DECISION DELEGATED TO HEAD OF PLANNING

Application No:	H14-0020-24	Applicant:	Ashwood Homes Ltd
Proposal:	Details of site levels & floor levels, construction management plan & method statement, estate road phasing & completion plan, adoptable estate roads & footways, surface water drainage scheme, on-site foul water drainage works, cycle store, acoustic barrier, landscaping & tree planting, boundary treatments, management plan for areas of publicly accessible open space & outdoor play areas, management & maintenance schedule, additional elevational treatments for plots 1, 2, 11, 67, 68 & 69, external boxes for gas & electricity supplies, gas flues & soil vent pipes, preliminary ecological appraisal, swift next bricks, biodiversity management plan, local area for play (LAP) & water consumption (Conditions 3, 8, 9, 10, 11, 12, 13, 14, 15, 16, 17, 18, 19, 20, 21, 22, 23, 24 & 25 of H14-1218-21)		
Location:	The Yews Farm Land Off Spalding Road Pinchbeck

This application is for a discharge of conditions 3, 8, 9, 10, 11, 12, 13, 14, 15, 16, 17, 18, 19, 20, 21, 22, 23, 24, 25 application relating to Planning Permission H14-1218-21.

Biodiversity Management Plan

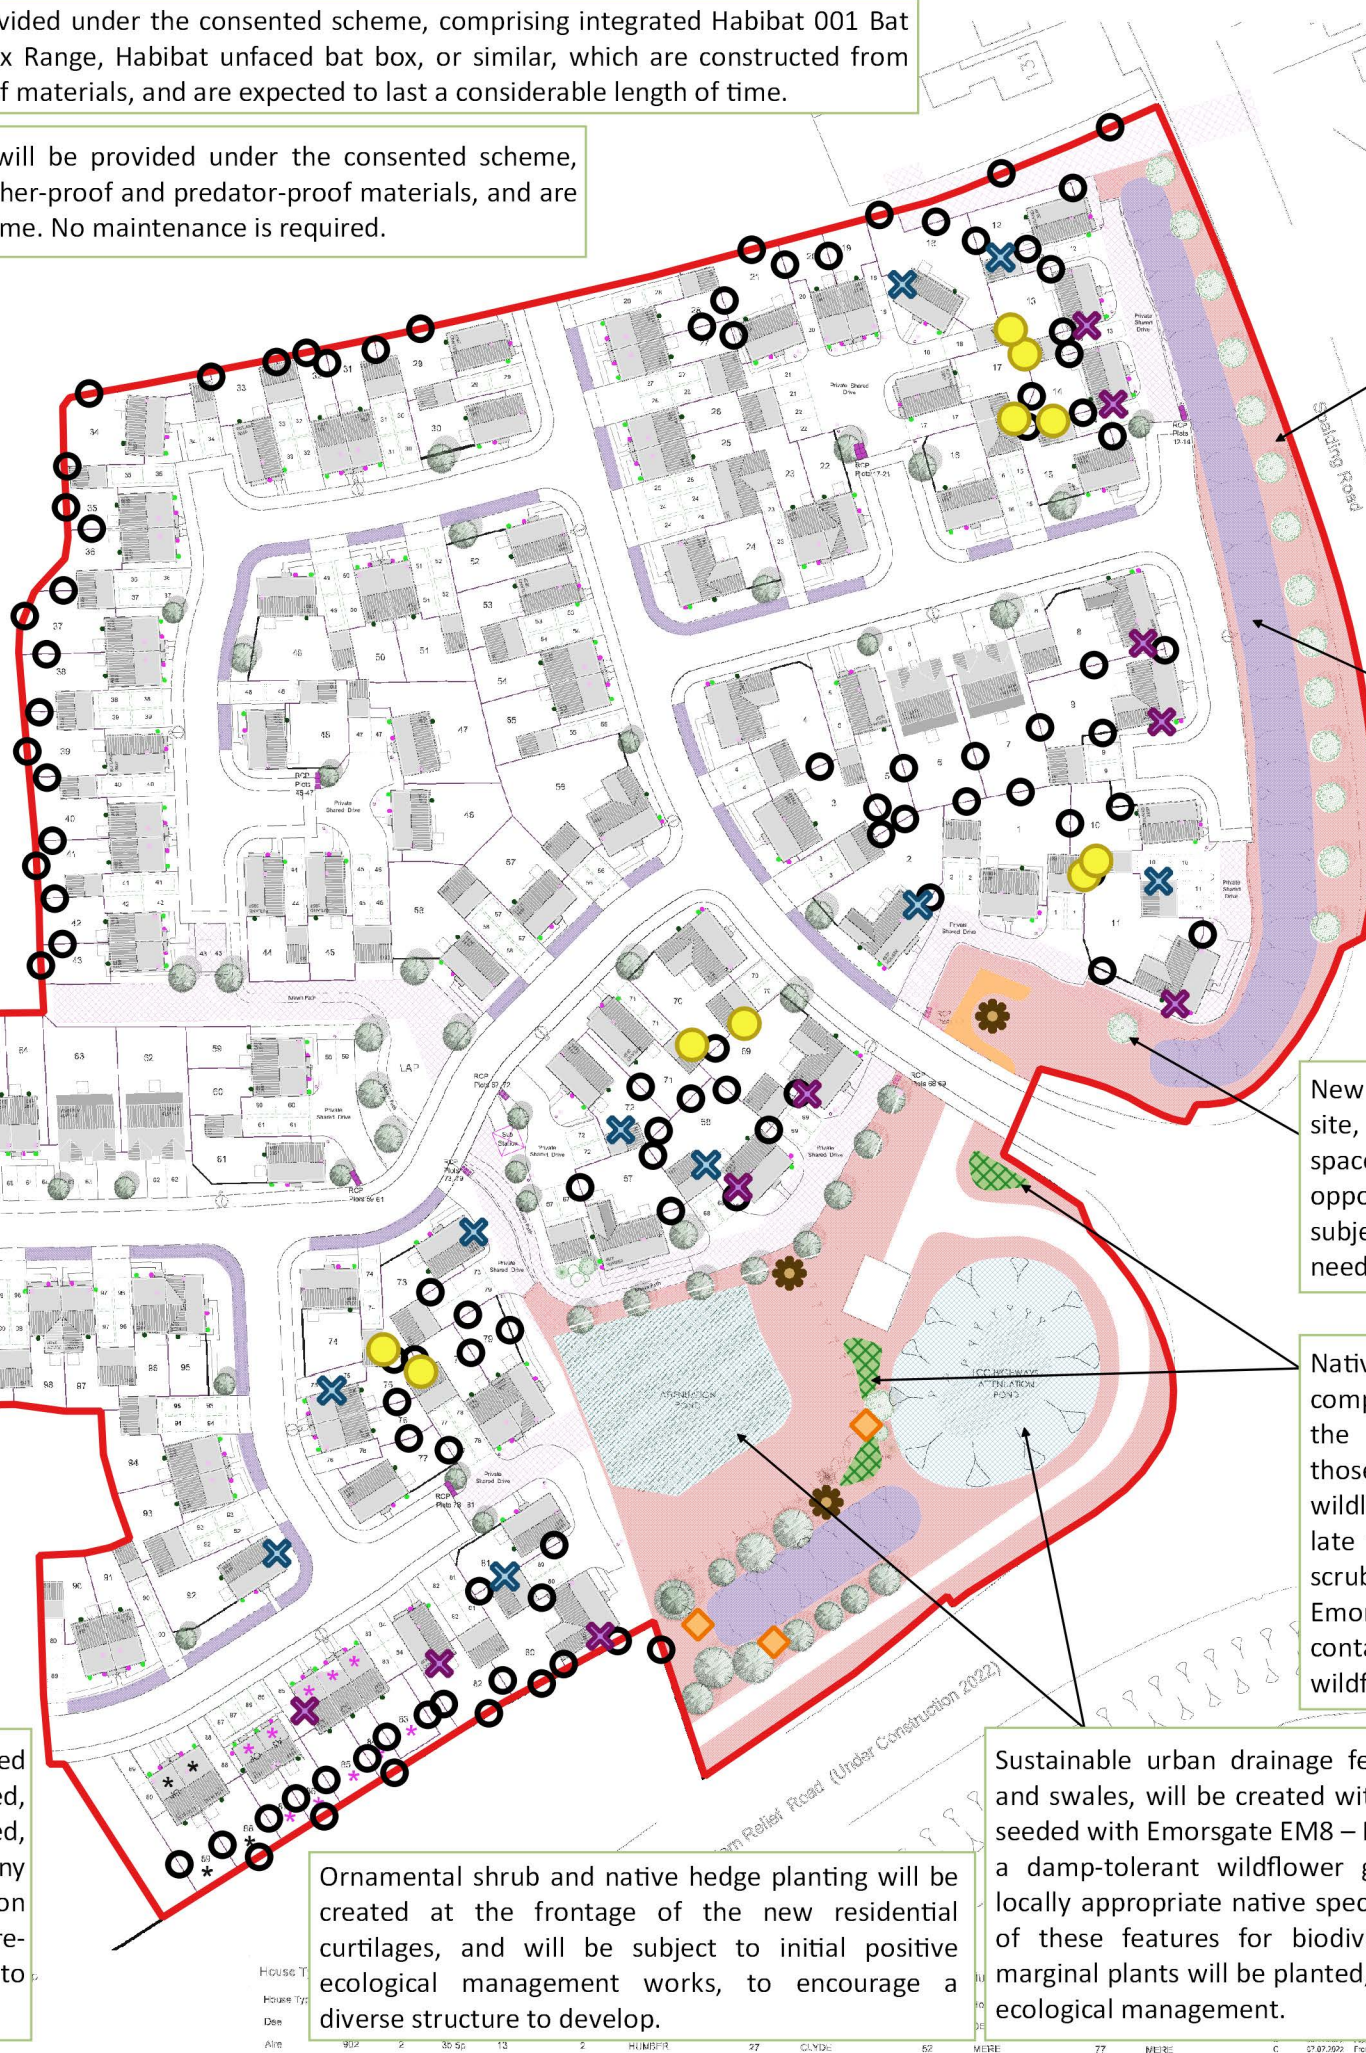
Regarding condition 22 - The Biodiversity Management Plan states that five swift nest boxes will be provided under the scheme, and no information on swift bricks has been included. This falls unacceptably short of the conditional habitat creation of three nest bricks per home.

Thank you for consulting Lincs Bat Group on the Biodiversity scheme. With reference to bat boxes, pleased to see they are to be integrated into the buildings, but 10, for a development of this size?! Two objections: one, there should be at least three or four times that number; and two, they should be sited well into the estate and well away from the existing and new busy main roads, given that there is the river to the south and mature gardens - which are of enormous and frequently

unconsidered important feeding areas for foraging bats - across Pinchbeck Road, which any bats are much more likely to cross if boxes are sited nearby, and risk being hit by cars. The gardens within the estate will themselves become important habitats as they develop. This doesn't appear to have been considered

The applicant has provided a bio-diversity management plan by Allied Ecology. Lincolnshire Wildlife Trust have made comments stating, "We consider the Biodiversity Management Plan prepared by Allied Ecology, if followed, sufficient to meet Condition 23". Lincolnshire Bat Group have objected to the amount of boxes for bats proposed, they feel that there should be more than 10. Also they should be sited well into the estate and away from the main road.

Notwithstanding the objection from LBT the bio-diversity management plan did not have an explicit requirement for bat boxes. Whilst some are located on dwellings closer to the main road all houses are buffered from the road through landscaping and POS. Lincolnshire Wildlife Trust do not have any objection to the overall biodiversity management plan.

PROJECT:	
Proposed Residential Development at Vernatt's Strategic Urban Extension Phase 1	
DRAWING:	
Acoustic Measures Plan Parcel 1 - Yews Farm 100 Plots	
SCALE:	1:500@A1
DATE:	DEC.2023
DRAWING No:	074-AMP-01

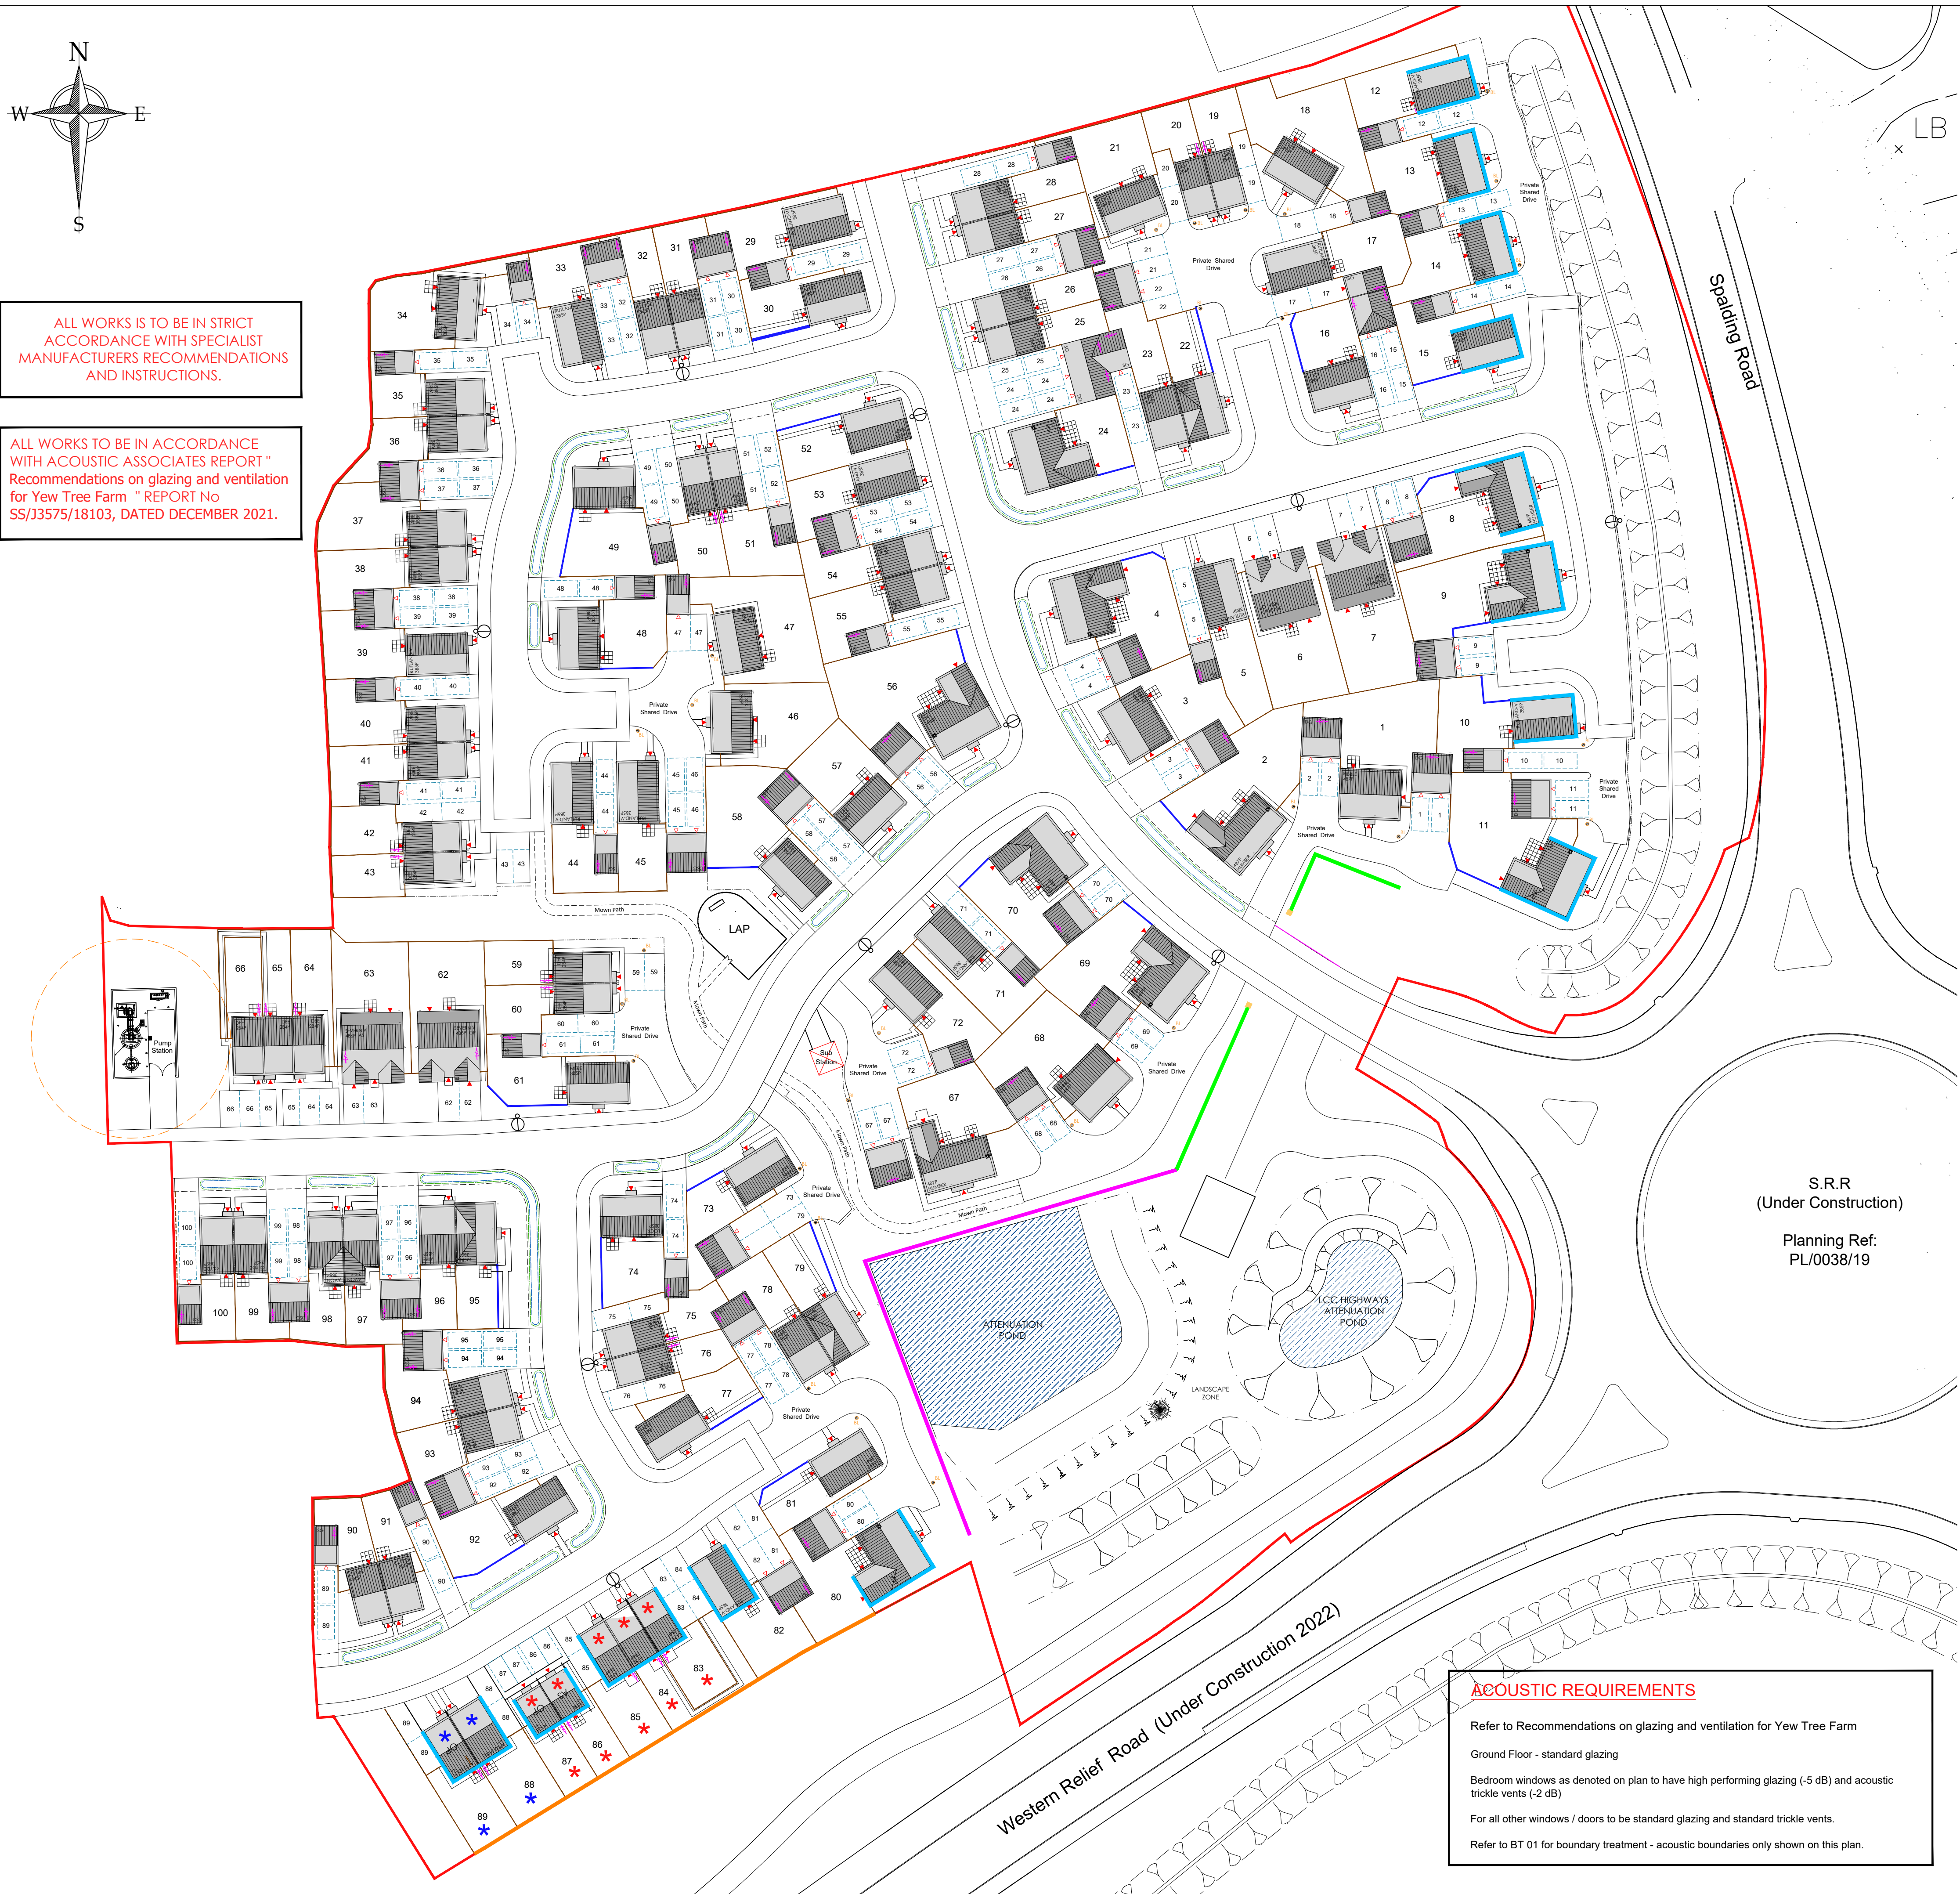
The applicant has provided an acoustic measures plan and boundary treatment plan. Environmental Protection have been consulted and have stated that the acoustic measures are acceptable.

PROJECT:	Proposed Ashwood Homes Development at Vernatt's Strategic Urban Extension Phase 1	
DRAWING:	LAP - LAND ALLOCATED FOR PLAY - GA AND DETAILS

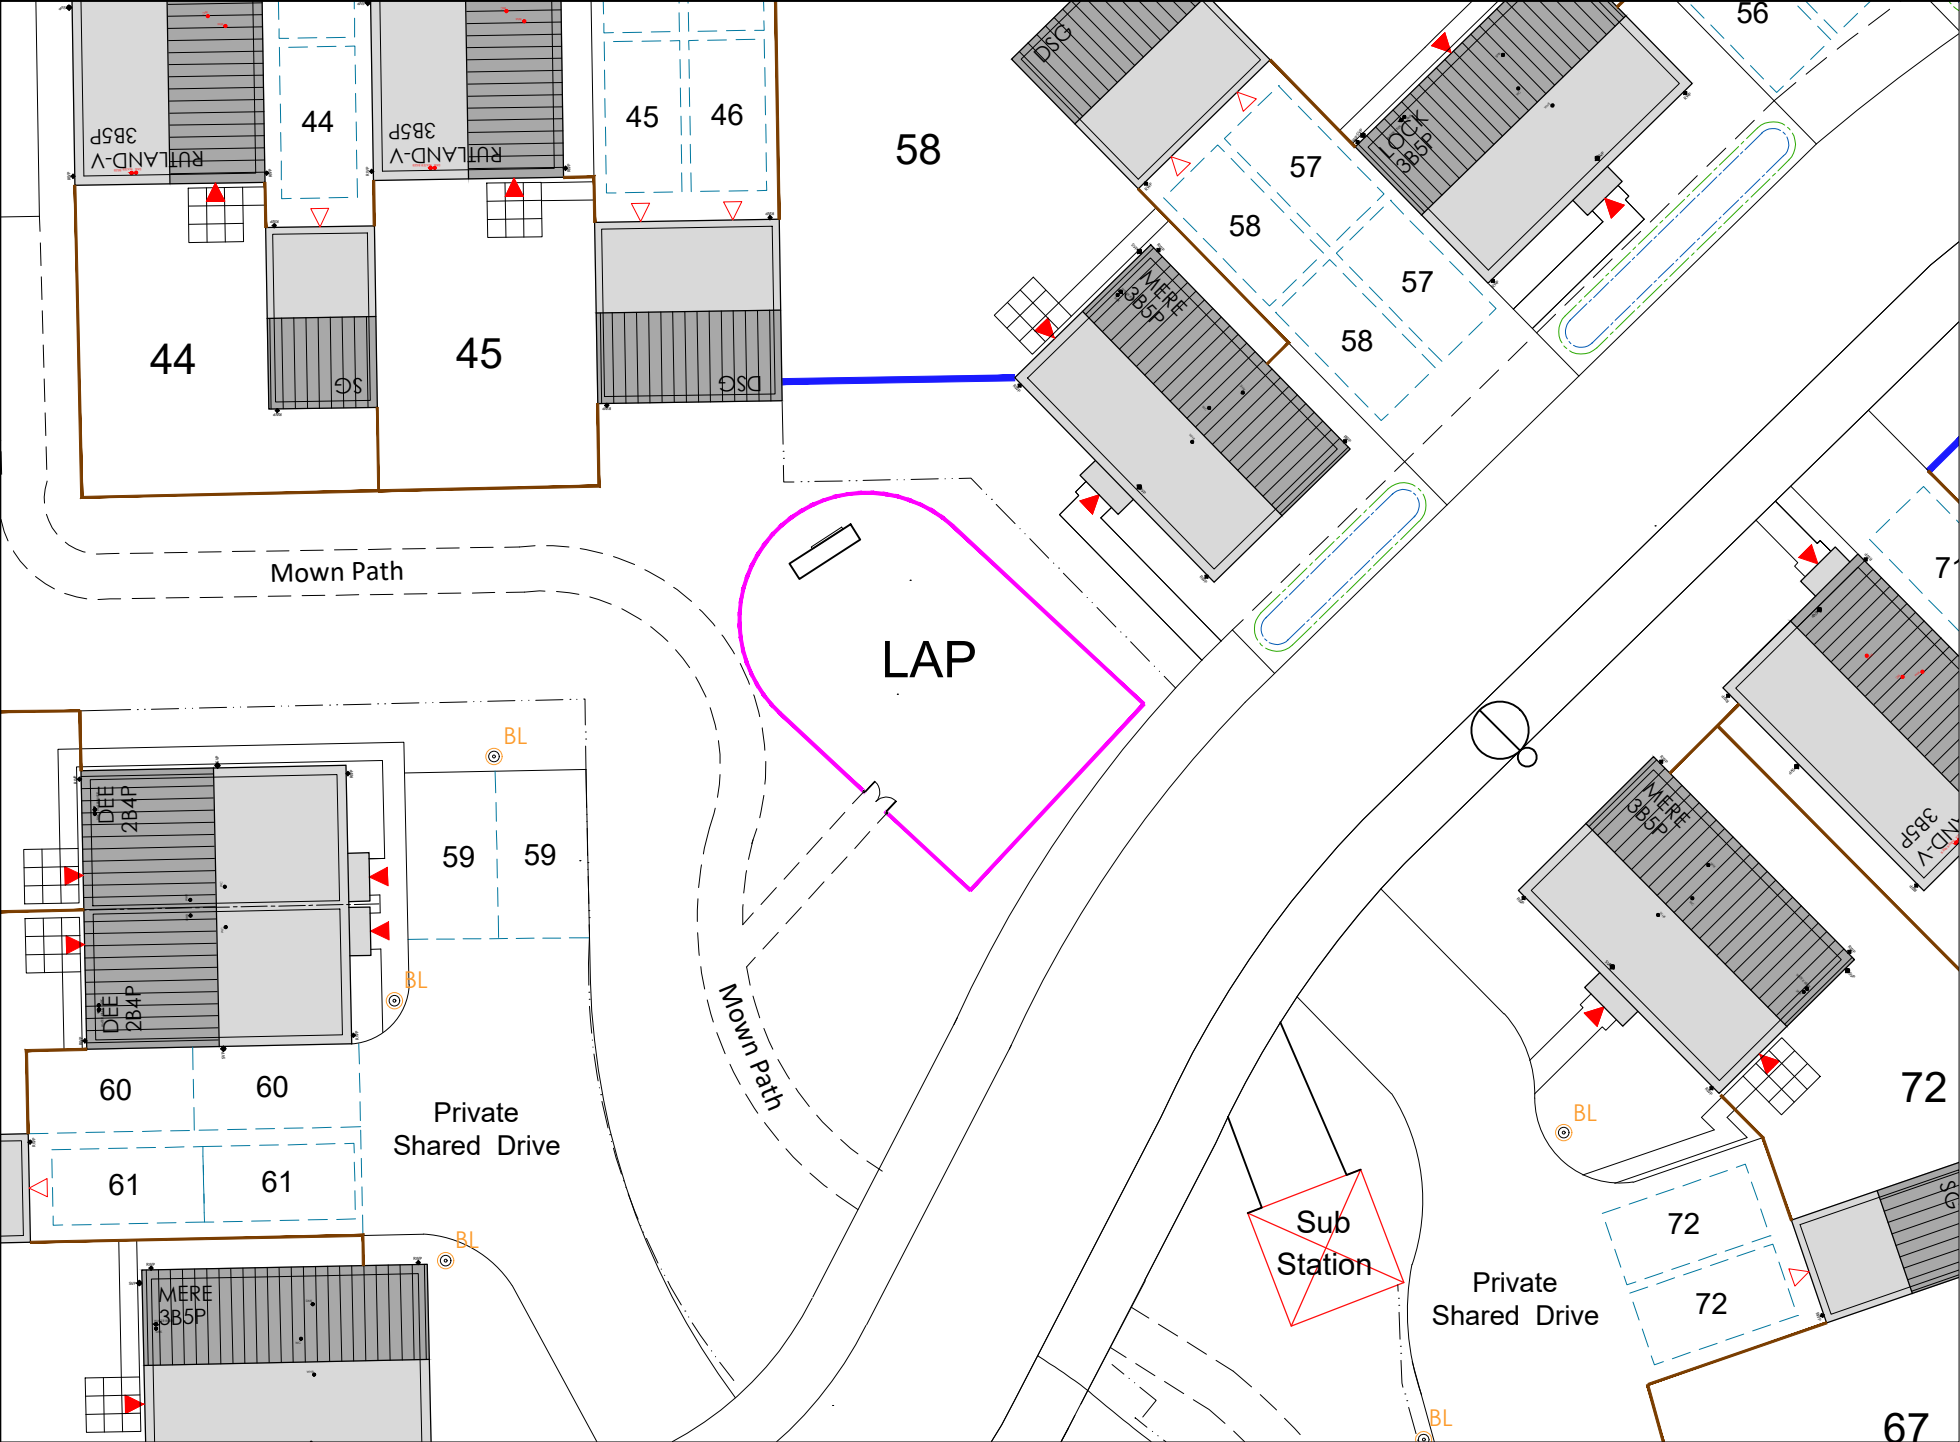
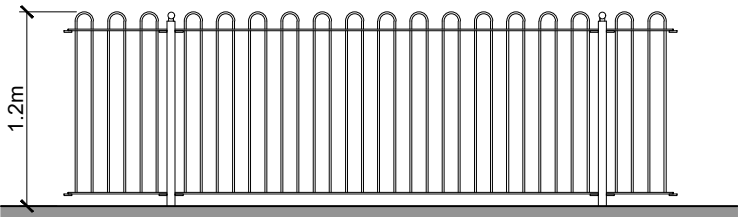
The applicant has shown an area allocated for the LAP, the details contain only a railed boundary and a bench within this area. Whilst the condition is explicit in requiring 'type of equipment' to be shown the original officer report states 'The LAP requires no play equipment as such, relying more on demonstrative features indicating that play is positively encouraged'.

Therefore, on this basis the LAP is considered acceptable. This condition was imposed in accordance with Policy 32 of the South East Lincolnshire Local Plan, 2019 and hereby discharged.
